Please upload as substitute plans for BR/275/19/PL

BR/275/19/HH at Newman Hose, 21 Sturges Road.

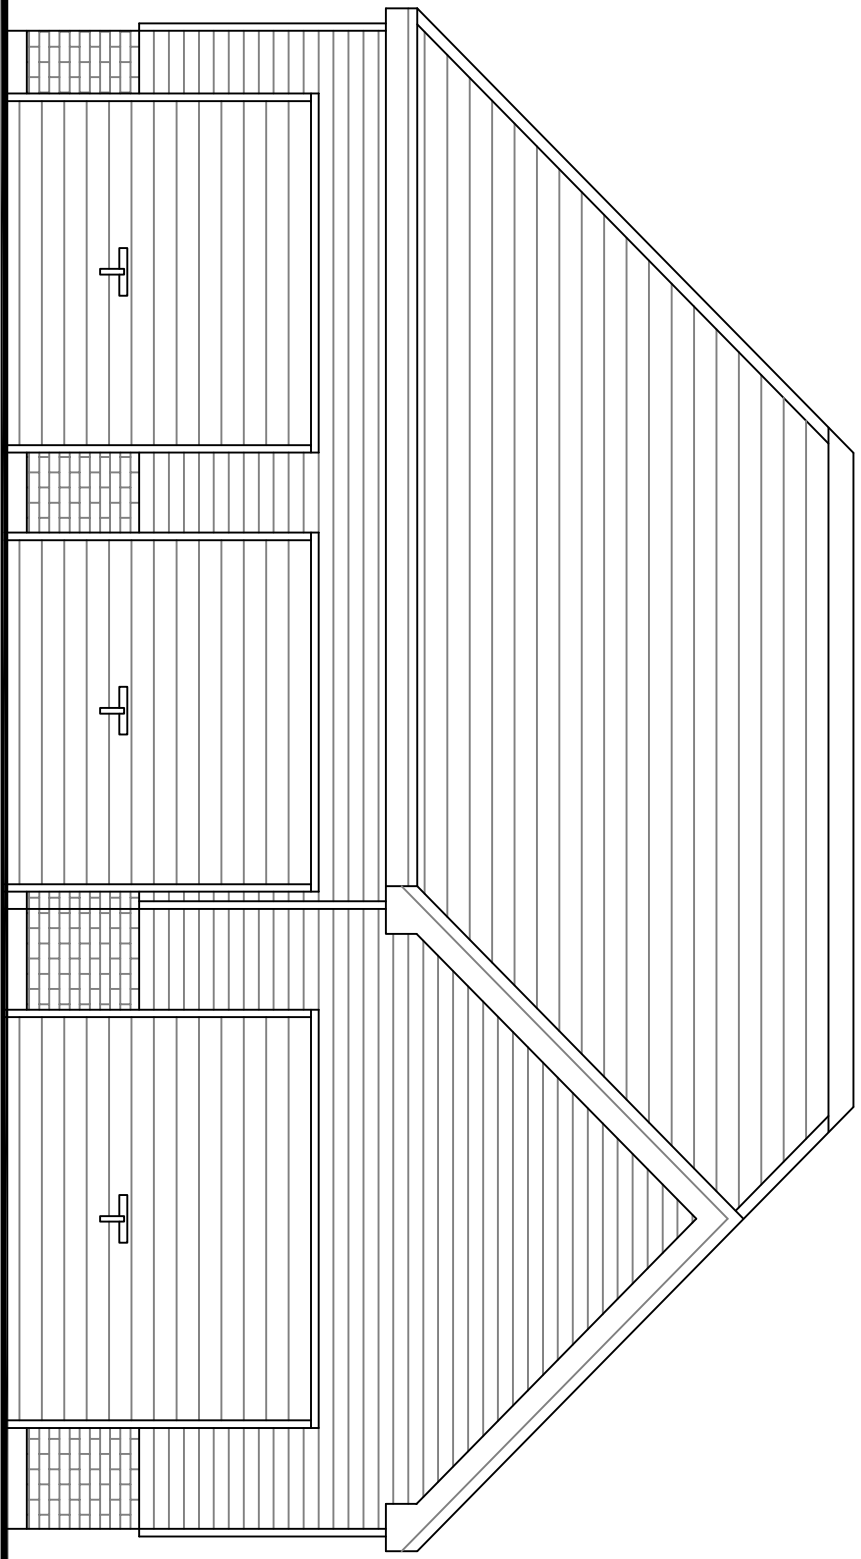
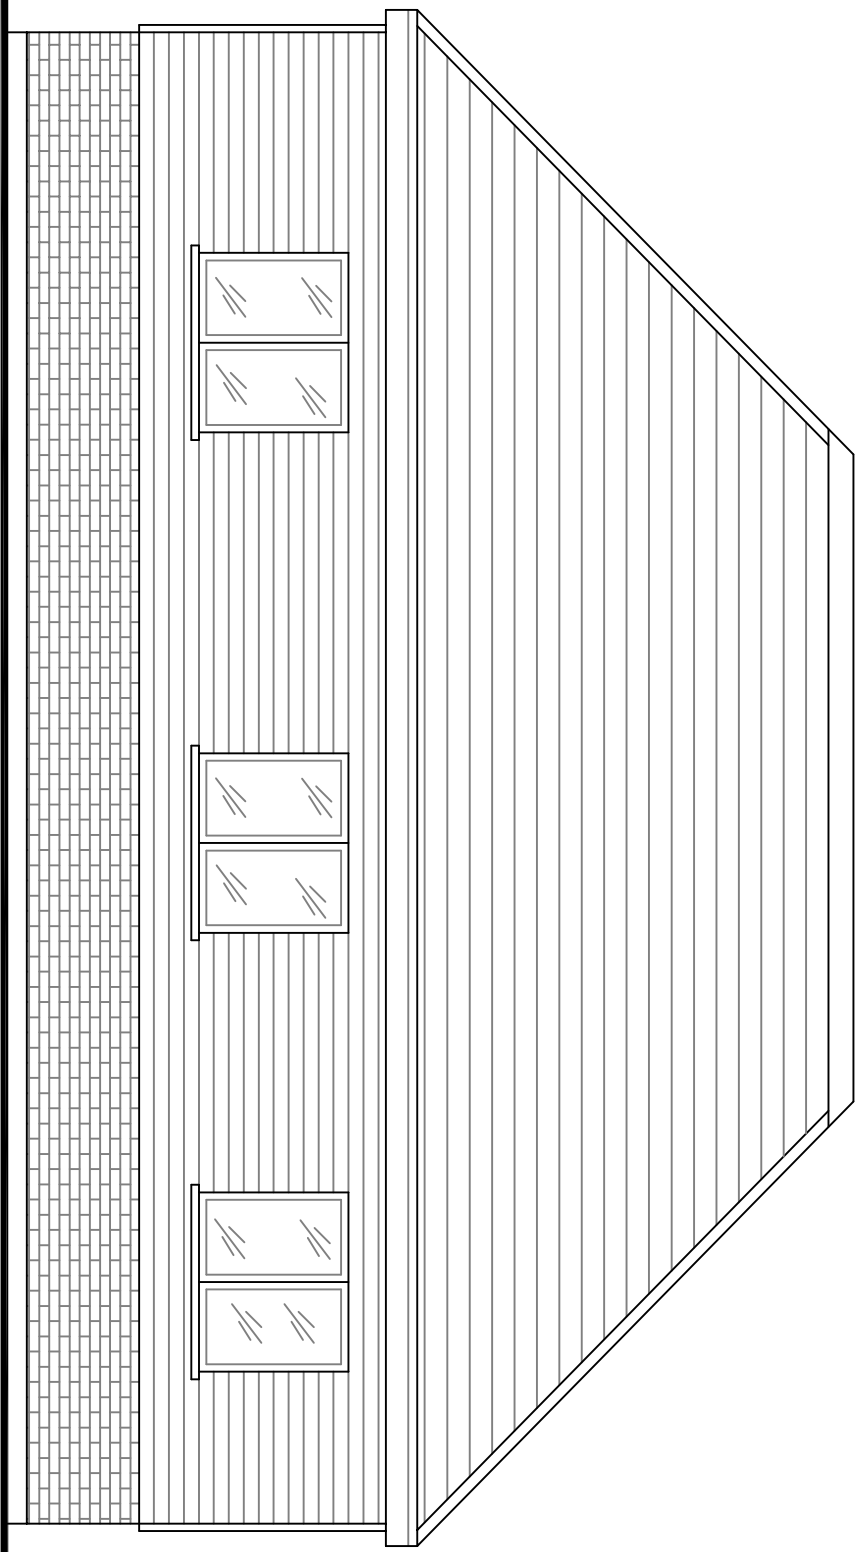
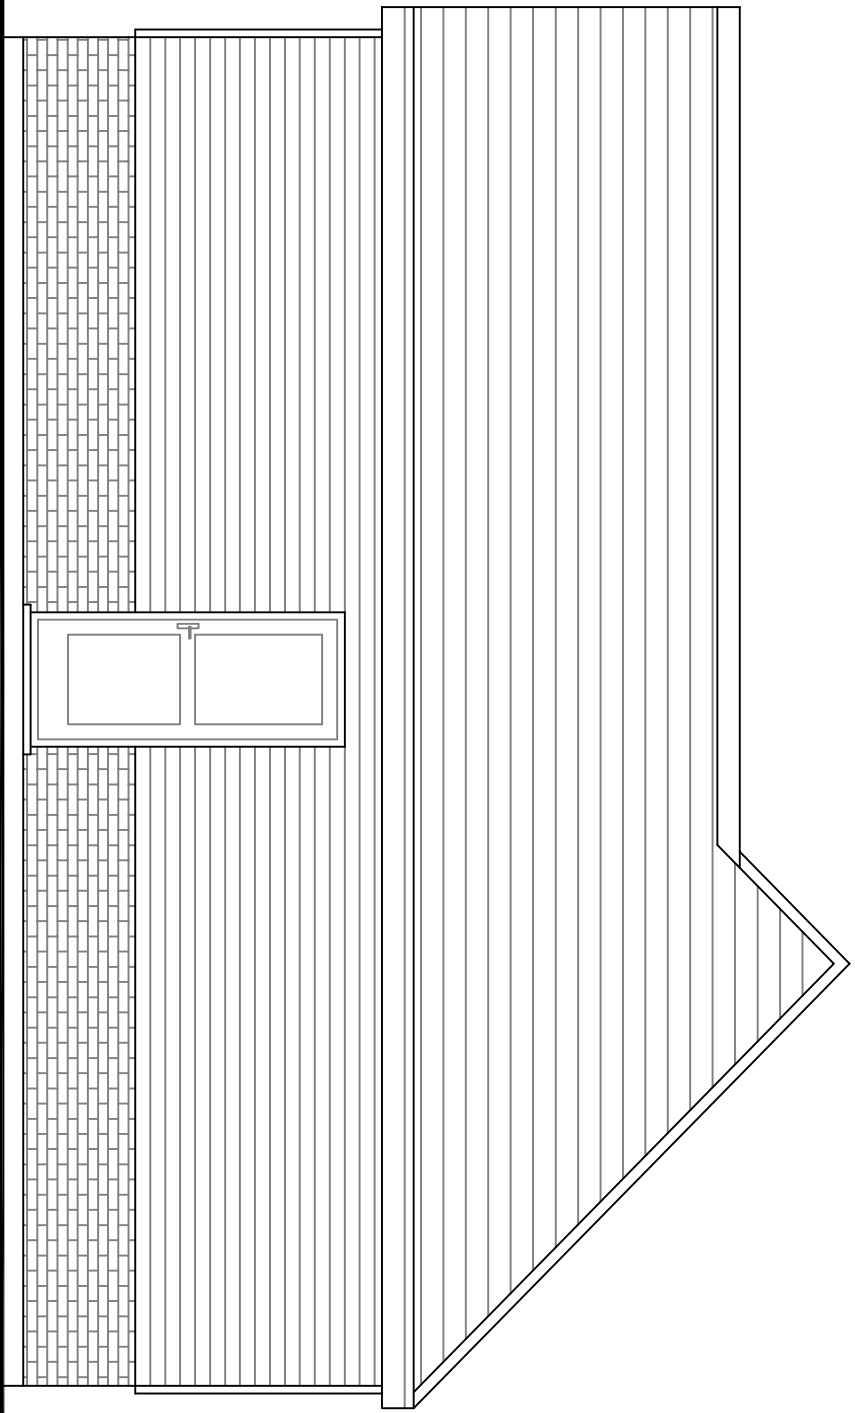
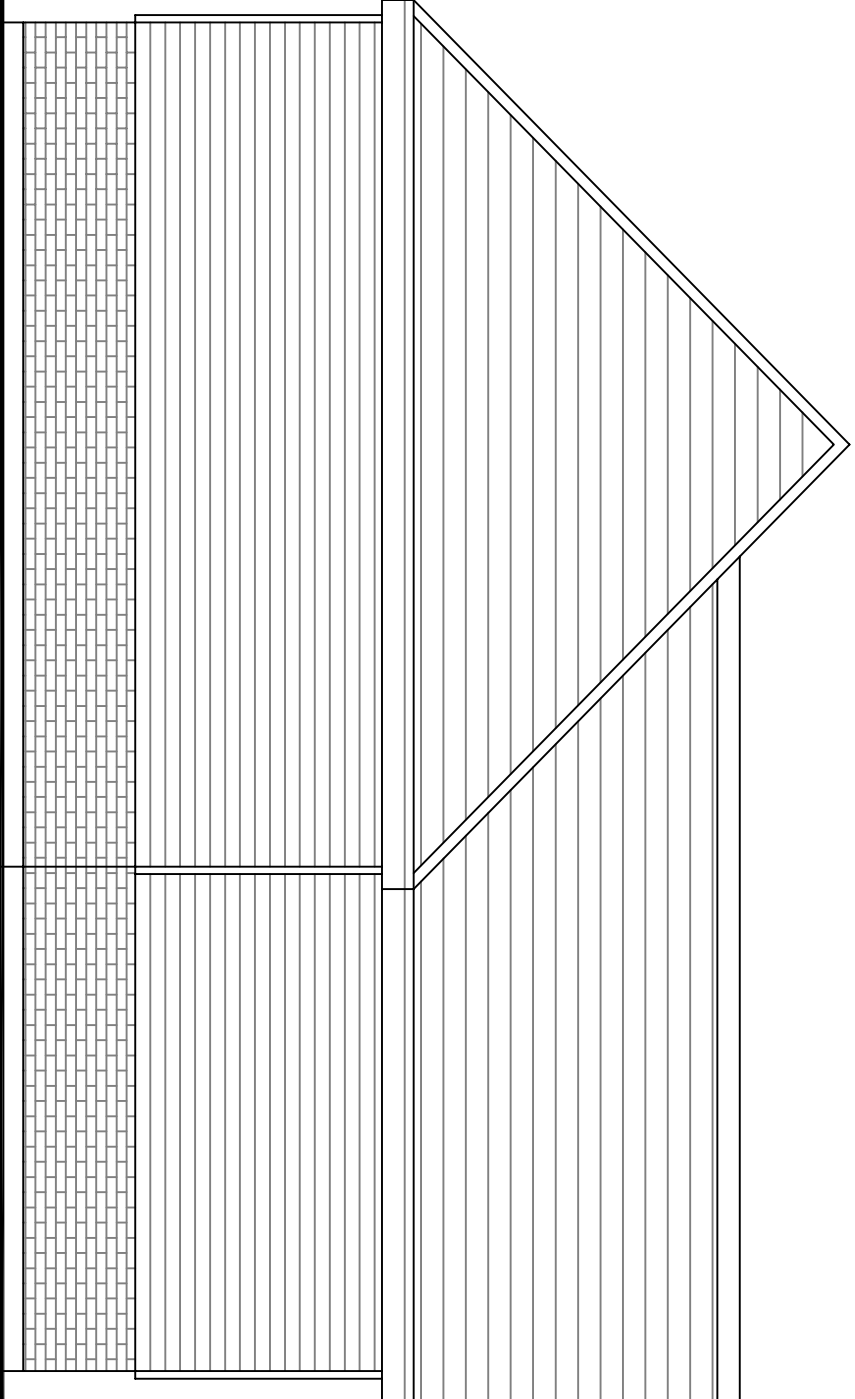
The garage structure is considered large for its location. Alternatives would be to reduce it to single storey and have a row of garages rather than an L shape block. However, the siting of this needs to ensure it does not give rise to adverse impact on the single storey neighbouring property which runs along the boundary to the north.

Proposed Ground Floor Plan

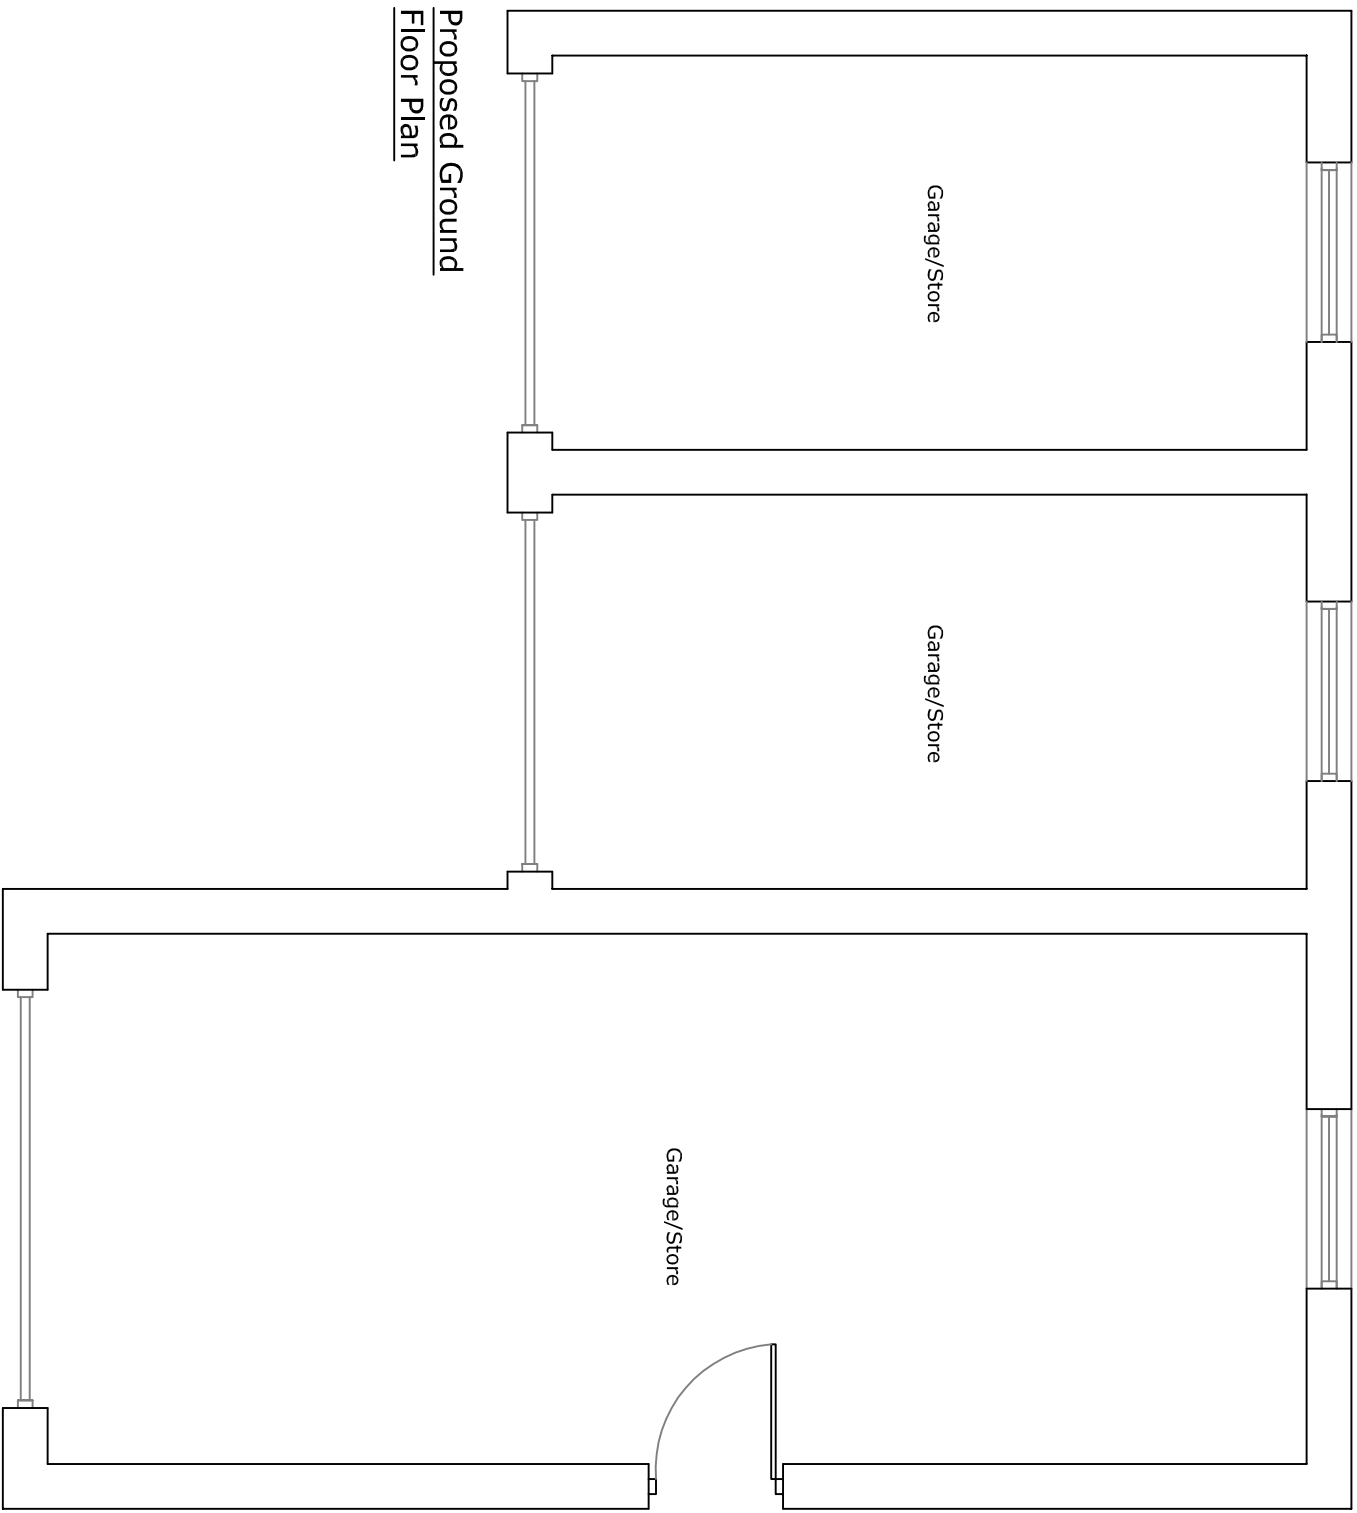
The structure would also remove allocated parking as approved on the application for the construction of the flats. The parking standards require a garage to be 3x6m to comply as 1 parking space. On measuring the plans the 2 smaller garages do not meet this and therefore the size would need to be increased to ensure that it meet the requirements and would sufficiently replace the space that is lost.
